Planning (Listed Buildings and Conservation Areas) Act 1990 (as amended)

Application for Listed Building Consent for Alterations, Extension or Demolition of a Listed Building

Development Listed Building Consent to replace dining room window with triple glazed plastic windows. Reduce size of replacement window. Replace bathroom & bedroom window at rear. The wooden back door in the dining room needs replacing to composite door.
Insulate rear outside dining room wall. Cladded & insulated with Marley Weatherboard. Replace the old existing guttering on the entire house from old plastic to deep fill cast iron effect guttering. Replace the rotten front door with a composite door. Repair the front sash windows.

Location 375 Chichester Road Bersted

Plans showing work to be done at cottage

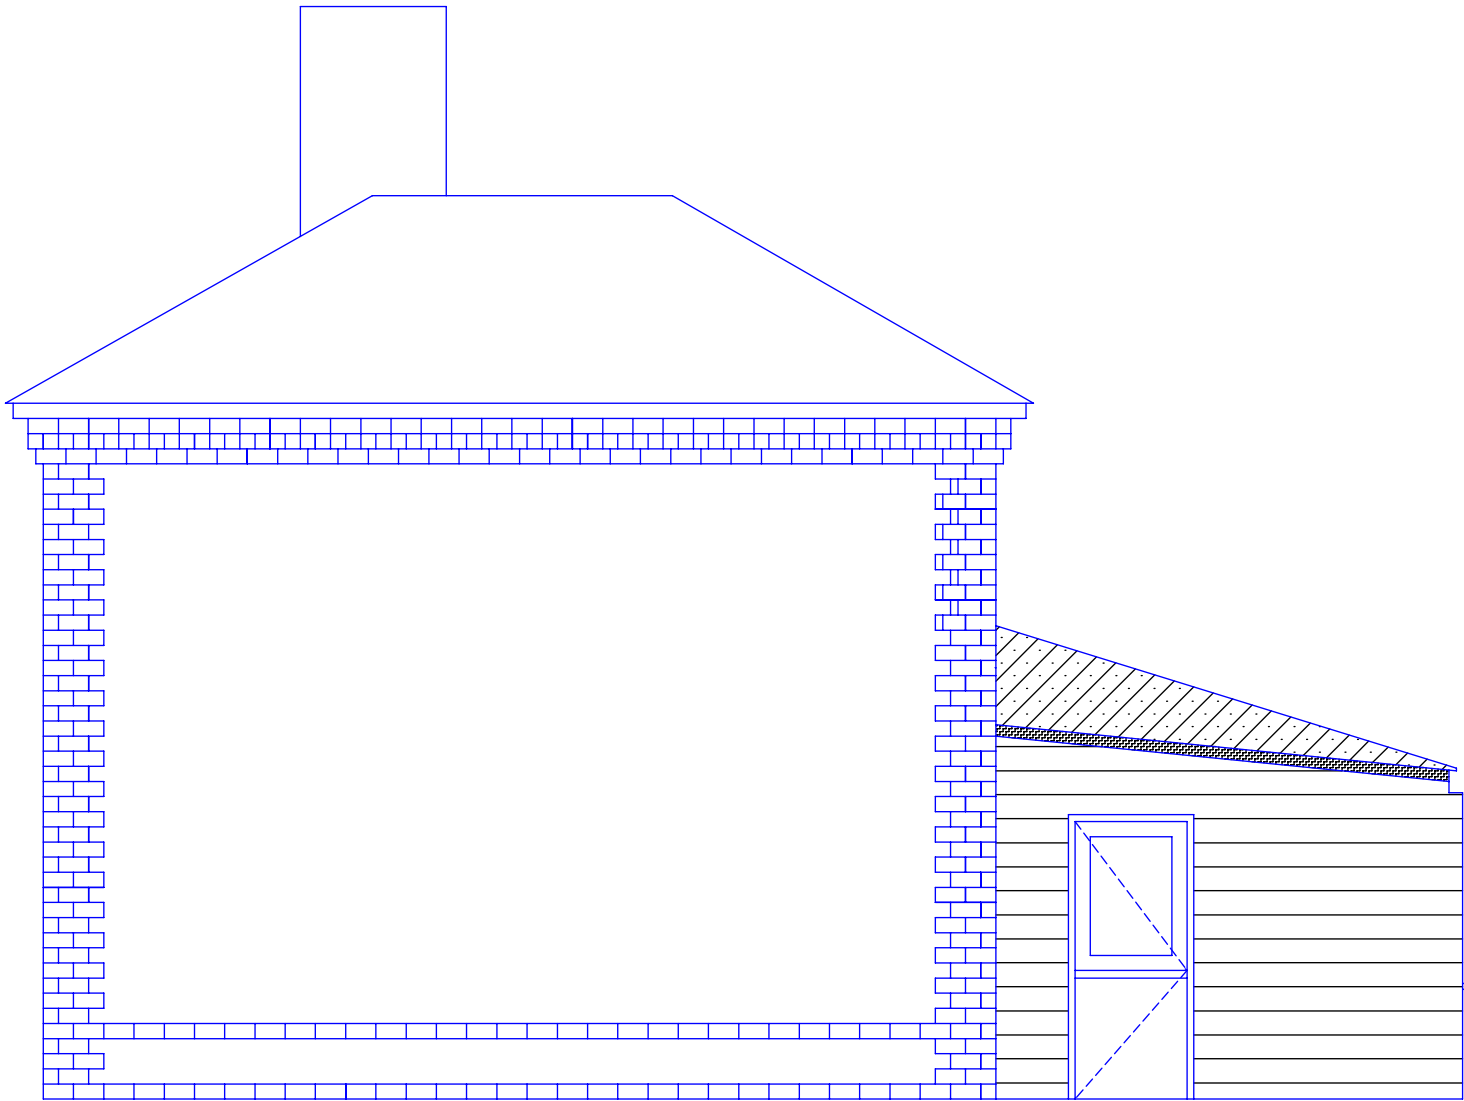
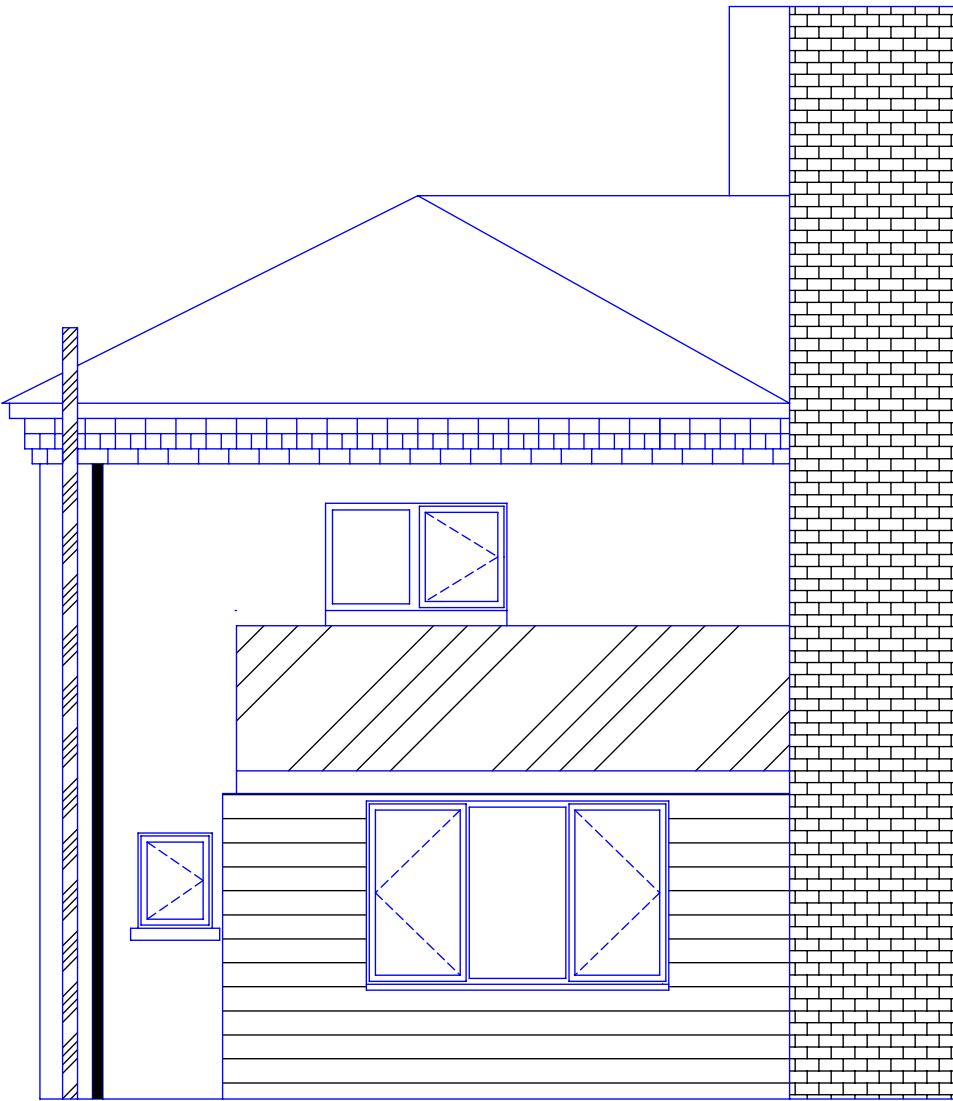
Please provide existing & proposed details/elevations (to scale) of the windows to be replaced.

Please provide elevations of the existing & proposed elevation to show the proposed cladding.

Plans of changes to cottage

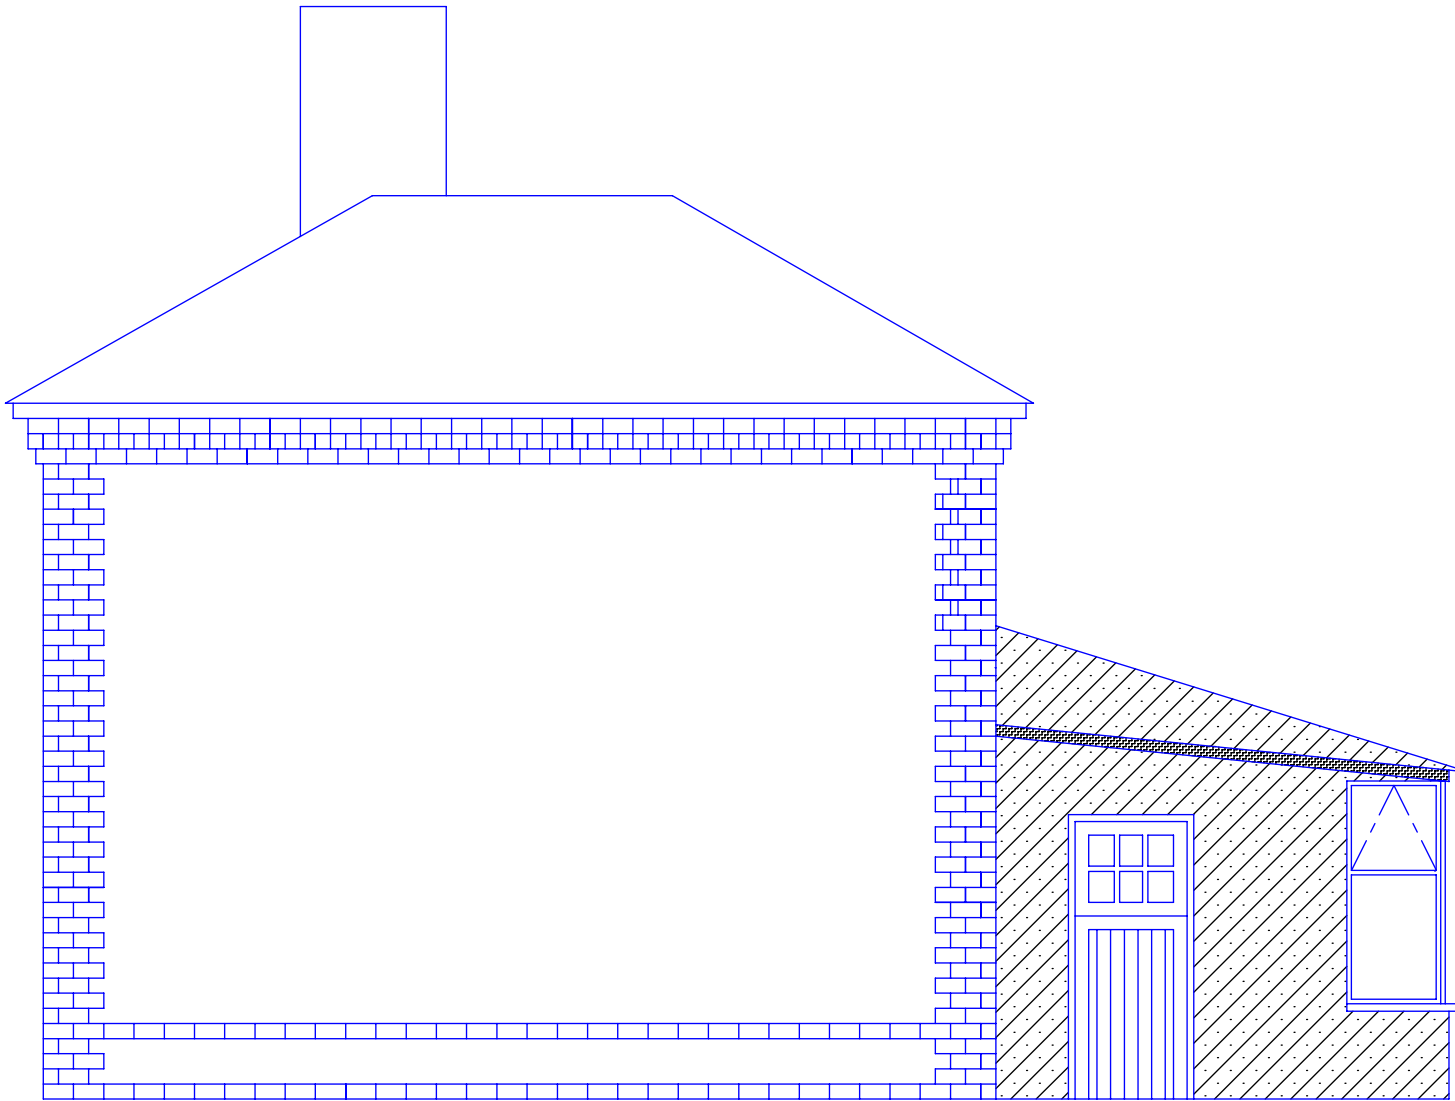
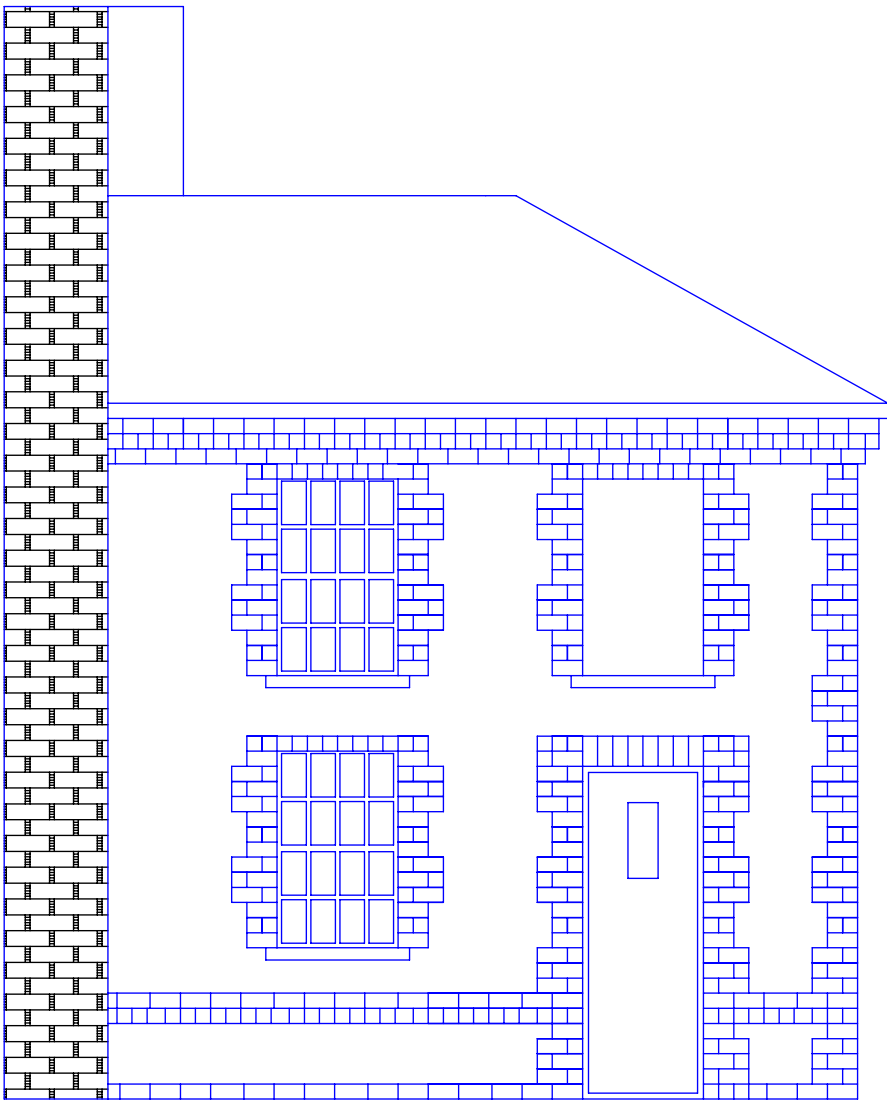
Please provide proposed details/manufacturers details of the existing & proposed guttering.
